MEMORANDUM

DATE: April 13, 2018

SUBJECT: WindingWalk at Meridian Ranch
The Enclave at Stonebridge at Meridian Ranch
PCD File No. PUDSP-18-002 & SF-18-002
Response to Comments Memorandum
LSC #174750

Following are the LSC Transportation Consultants, Inc. responses to the El Paso County Planning and Community Development comments regarding the January 12, 2018 Traffic Impact Analysis by LSC.

Figure 3

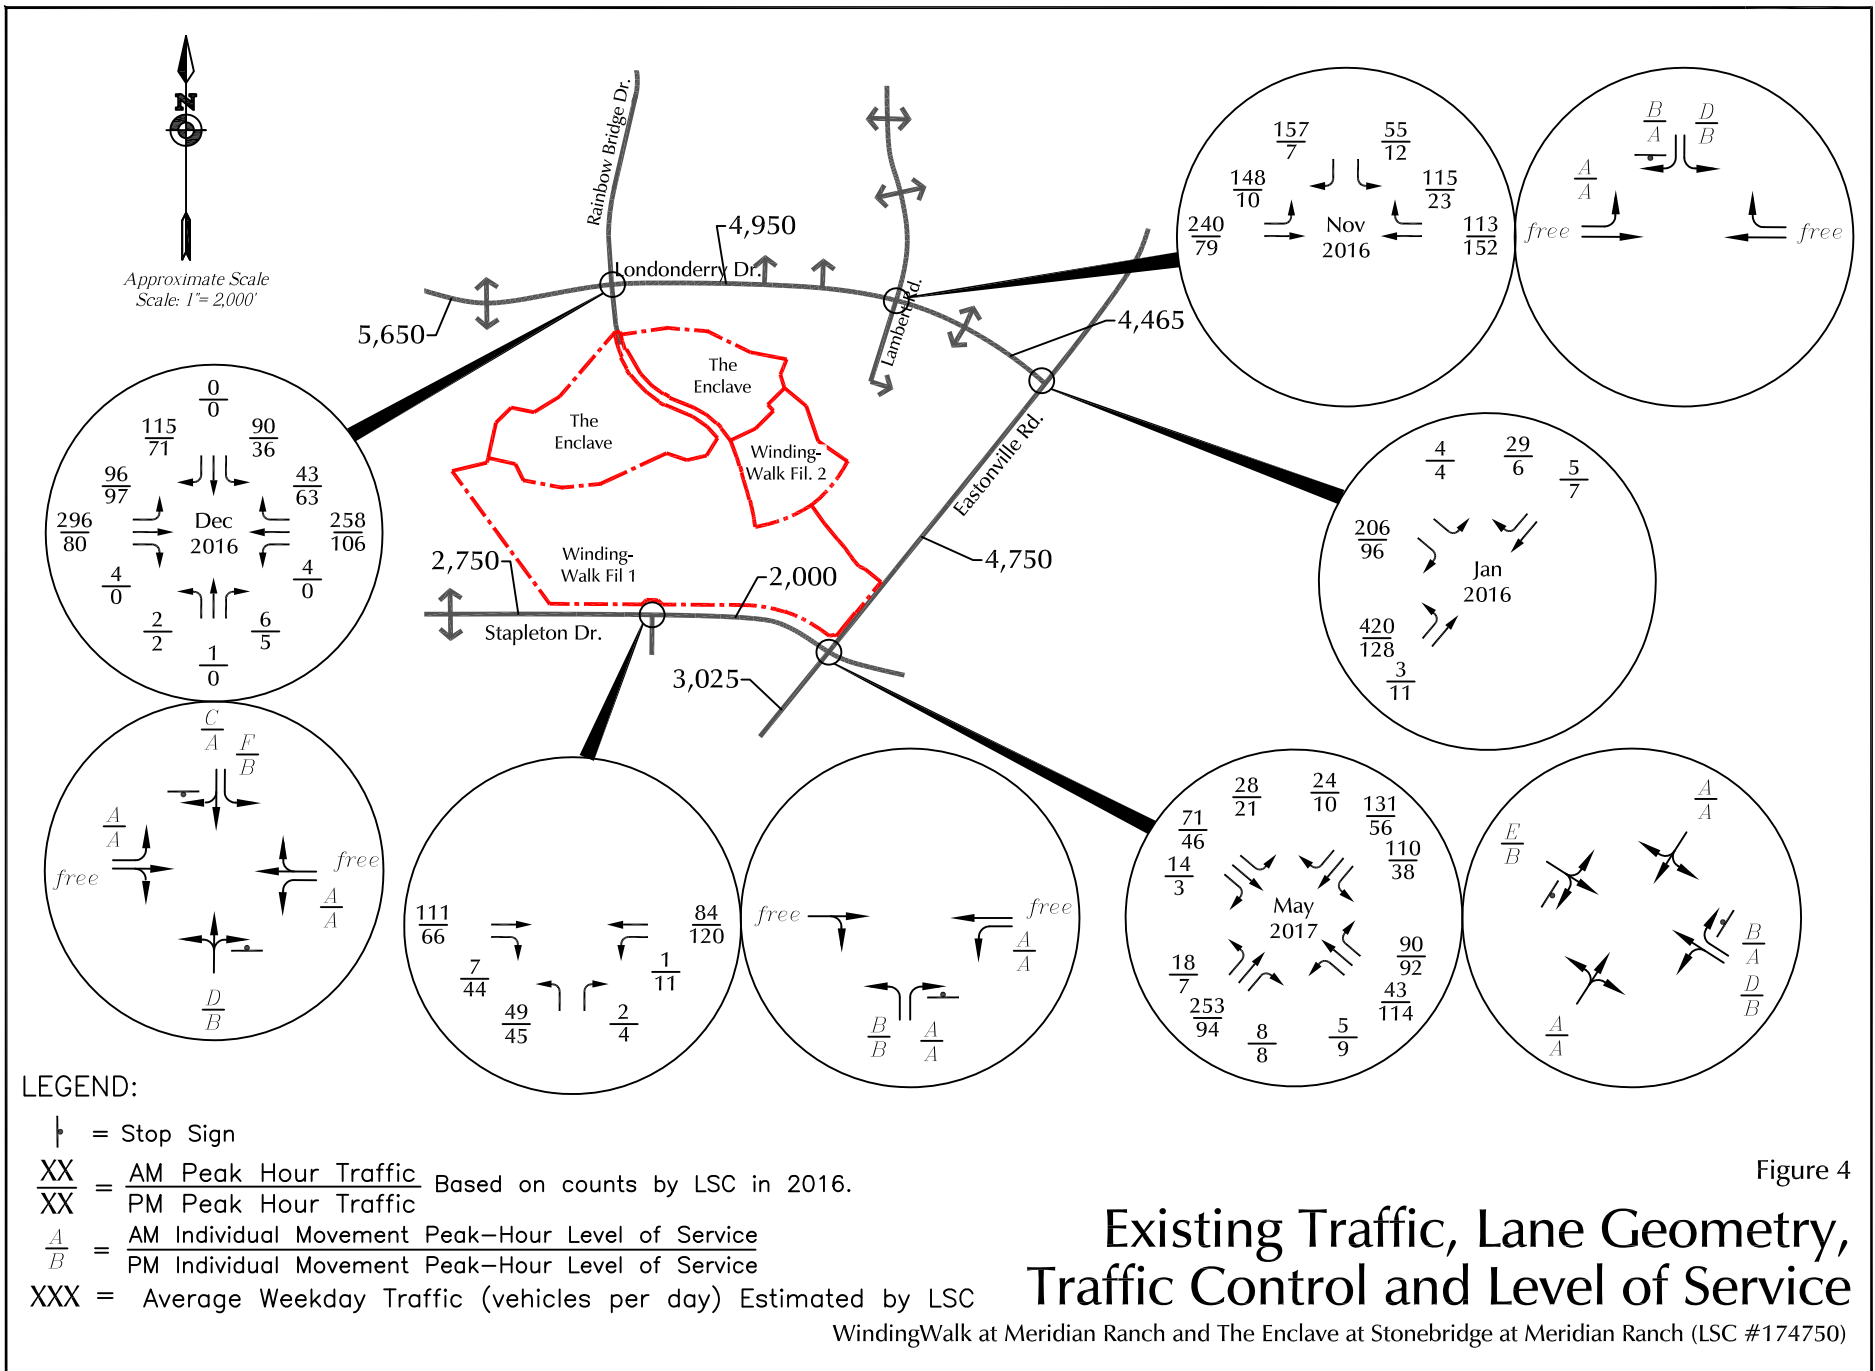
Page 22: Does not match Figure 3

LSC Response: Revised as requested.

Figure 20

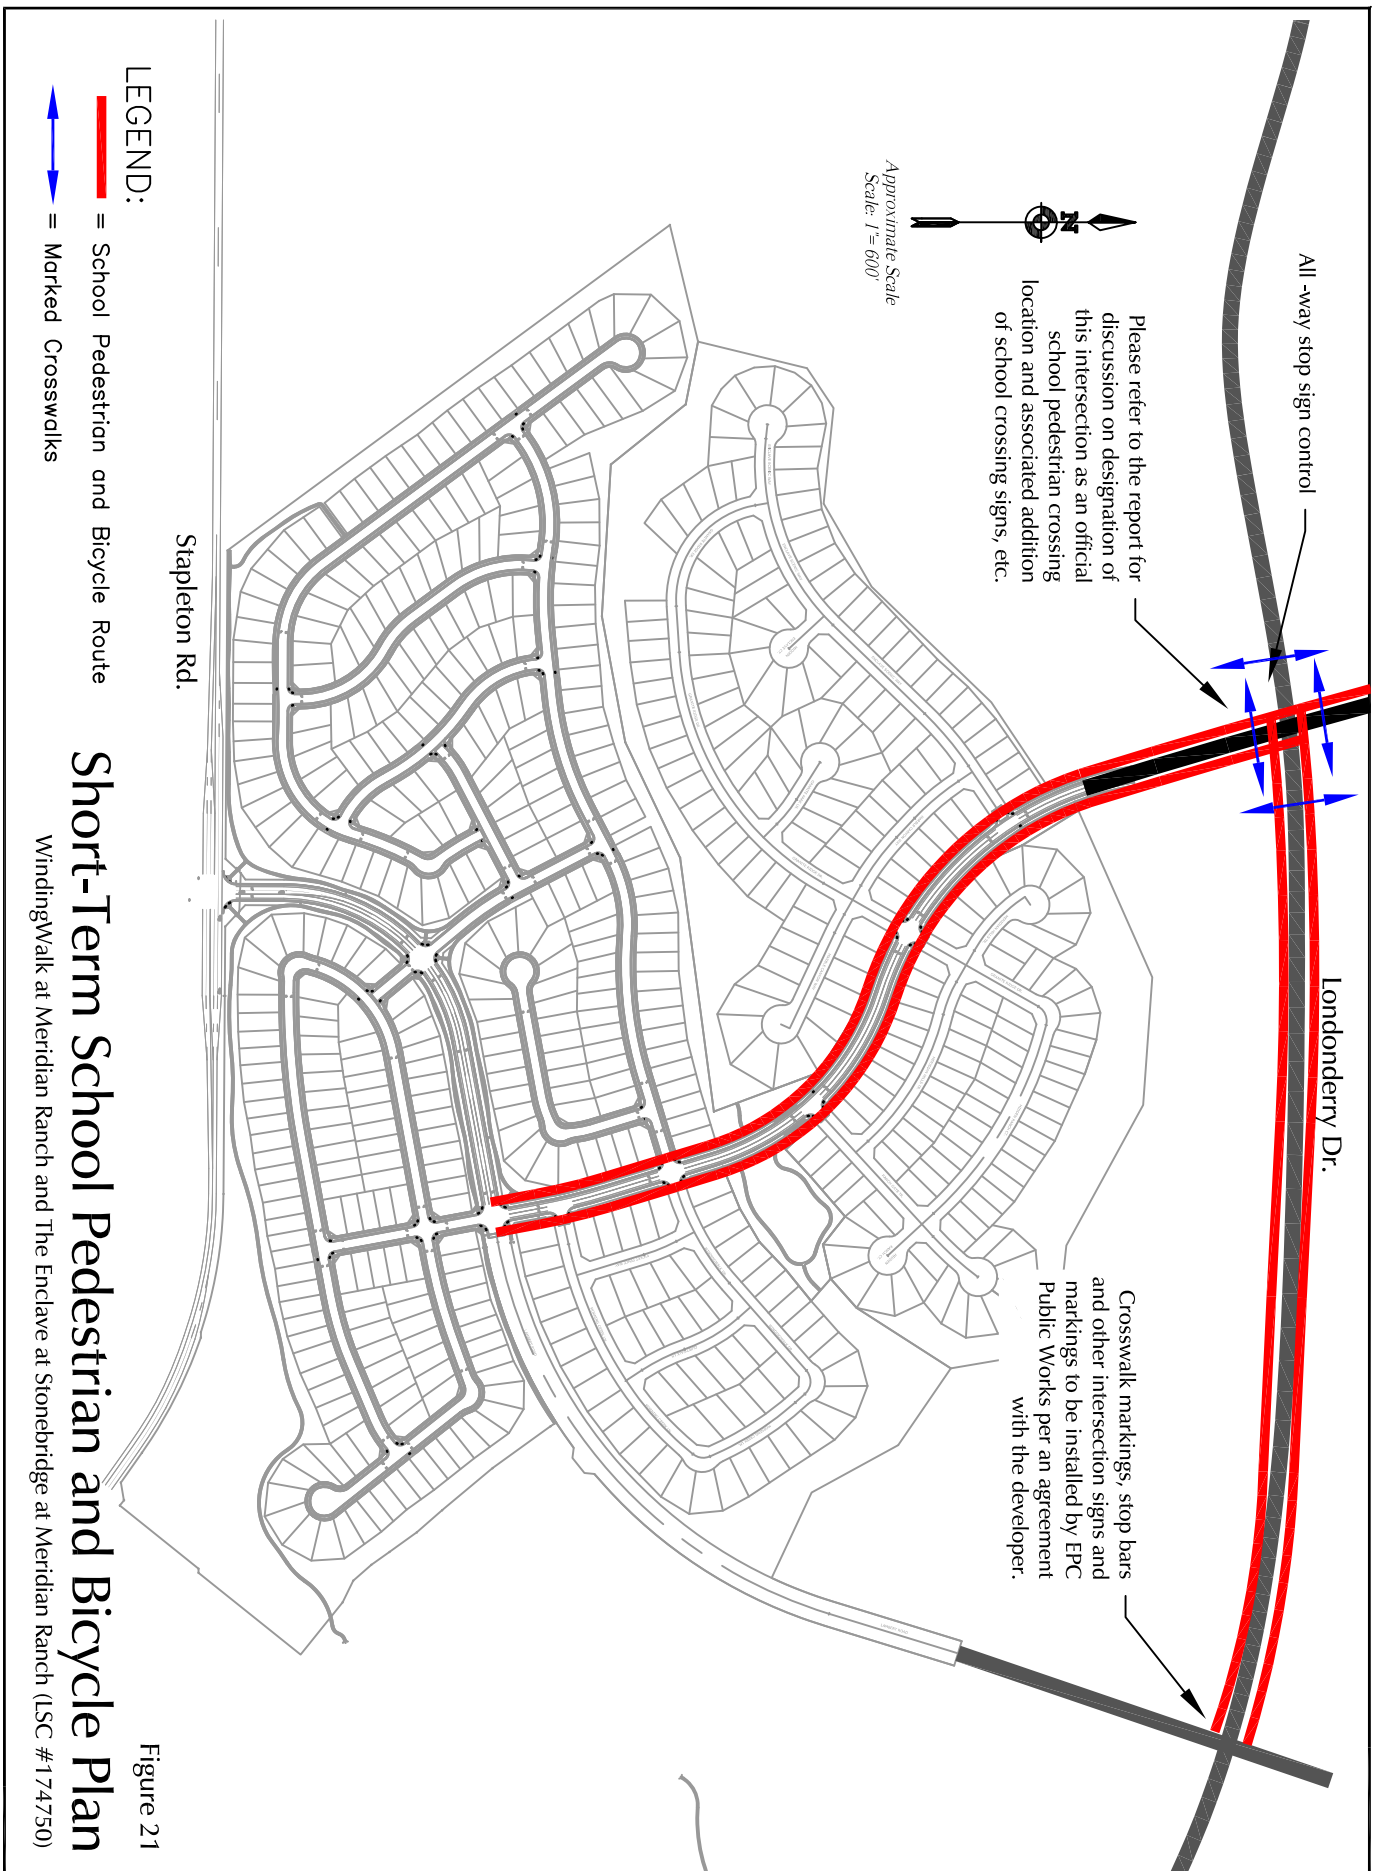
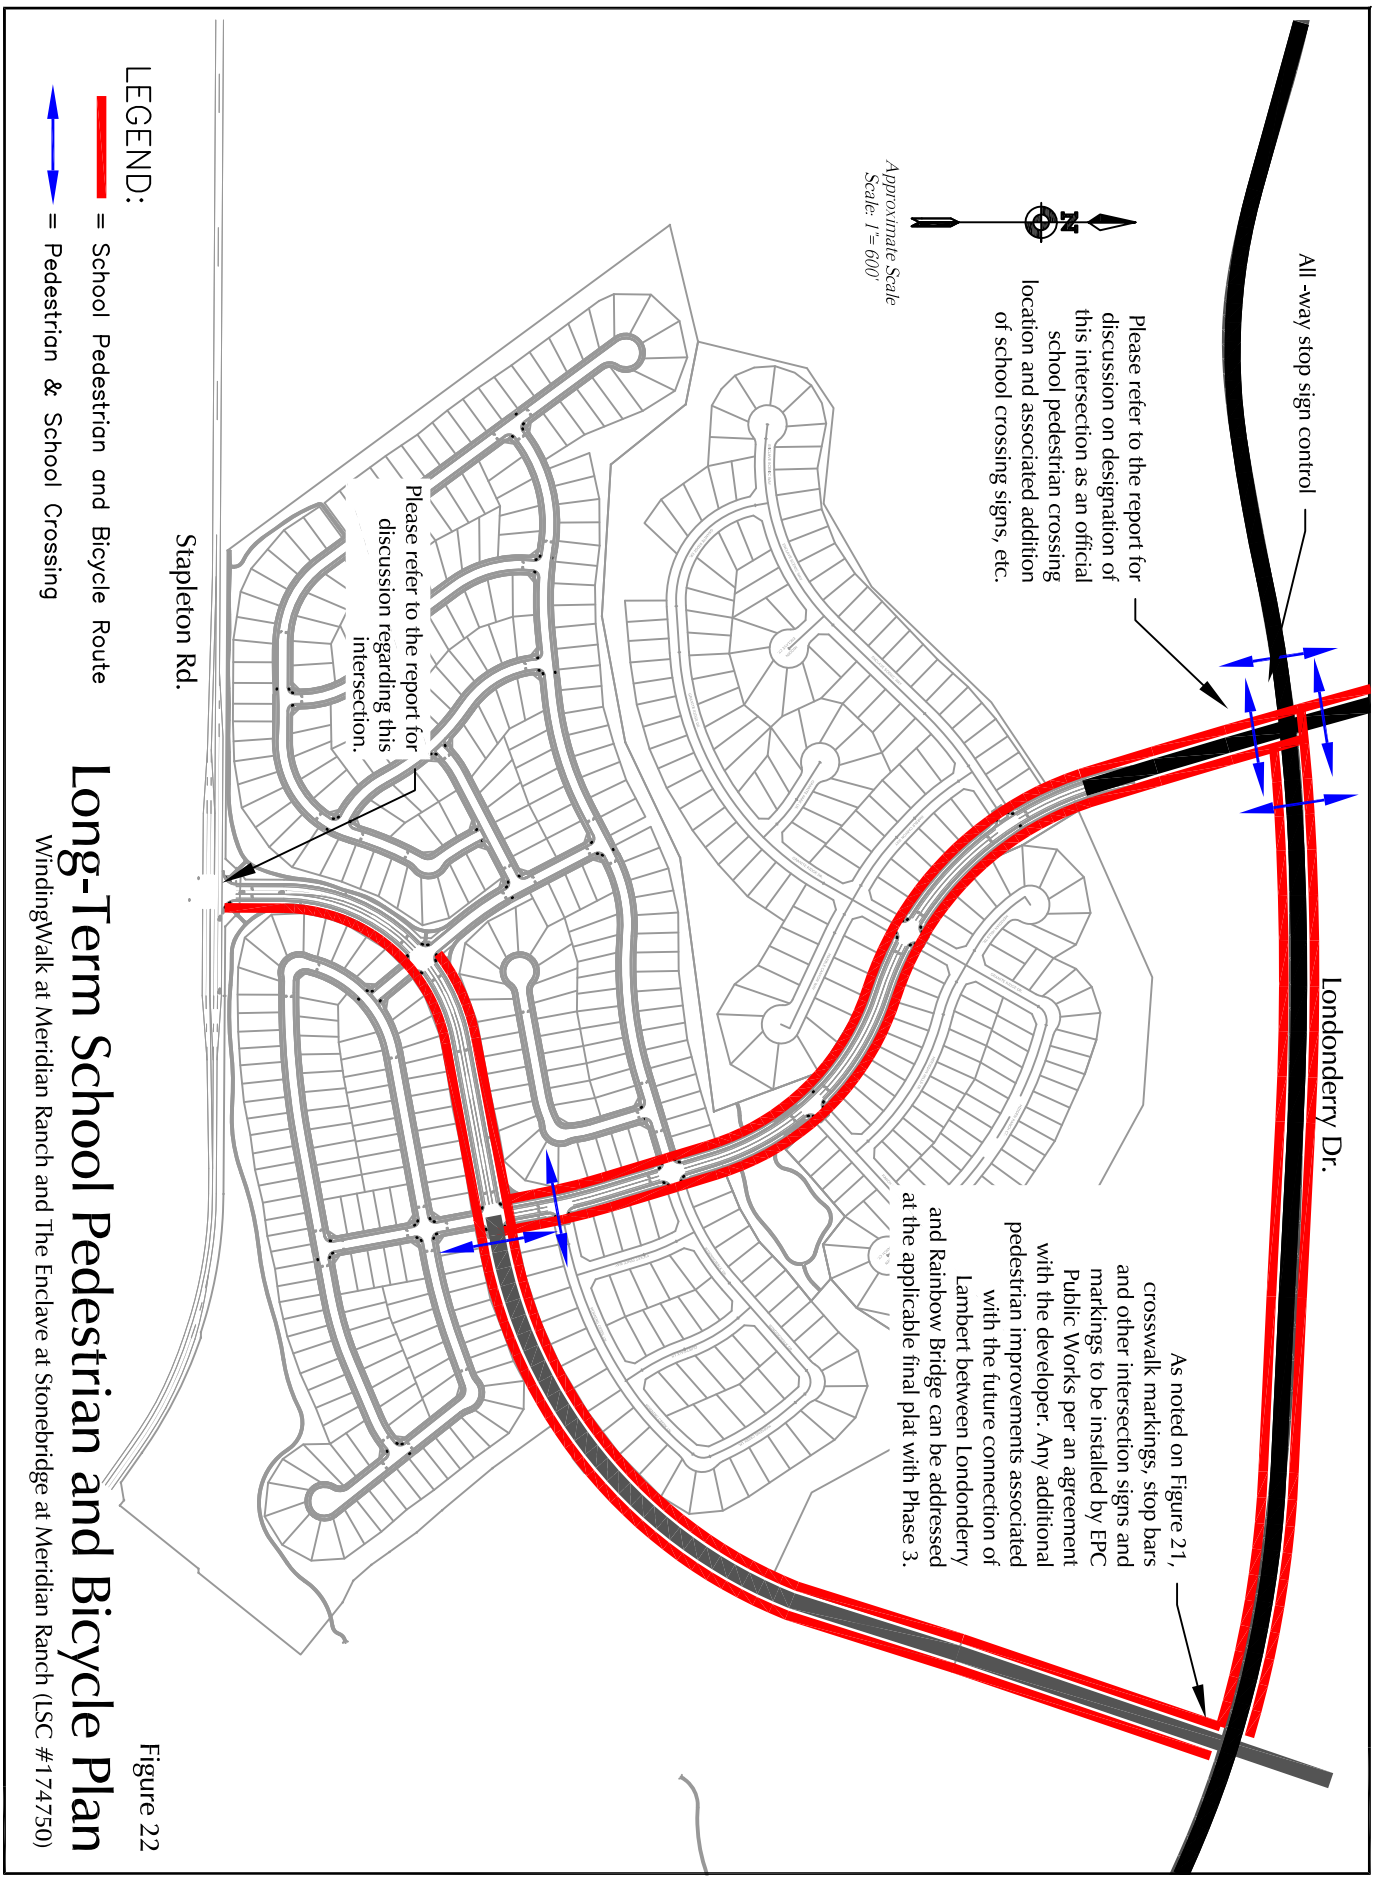
Page 15: Provide pedestrian and bicycle impact evaluations to include showing the school routing plans. See ECM B.4.1.C & B.4.1.D.

Provide analysis/proposed improvement recommendations regarding pedestrian crossing to the south at the Stapleton Dr/Lambert Rd intersection. It appears that the the proposed sidewalk in Meridian should extend to connect to the existing sidewalk south of the intersection.

LSC Response: This has been added to the updated report.
